Planning Application No: 3/2025/0435

Proposal: Proposed two storey side extension and rear bay window.

Location: 6 The Grove Whalley BB7 9RN

PROPOSED GROUND FLOOR PLAN SCALE 1:100

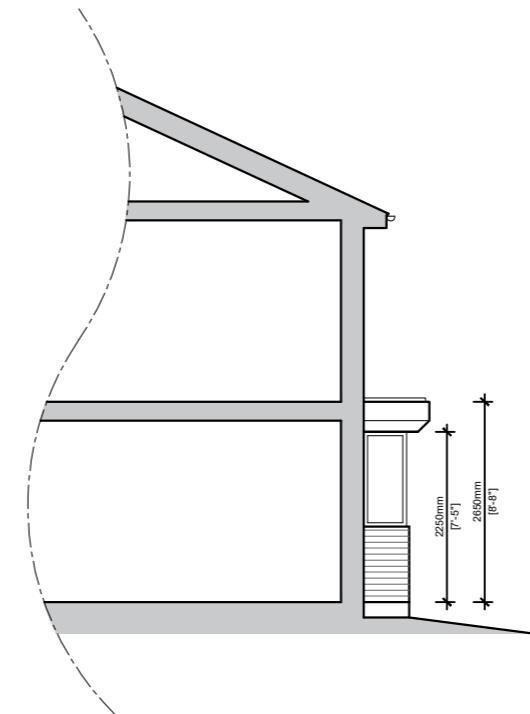
There is loss of a garage with this proposal. No parking plan has been submitted. A parking plan is required to show the 3 parking spaces required by parking standards can be achieved with the curtilage of the property. If the vehicular crossing needs to be extended across the parking area to prevent damage to the footway then please see the informative note below. The dwelling is on a cul de sac and parking on a turning head is not permitted for highway safety reasons.
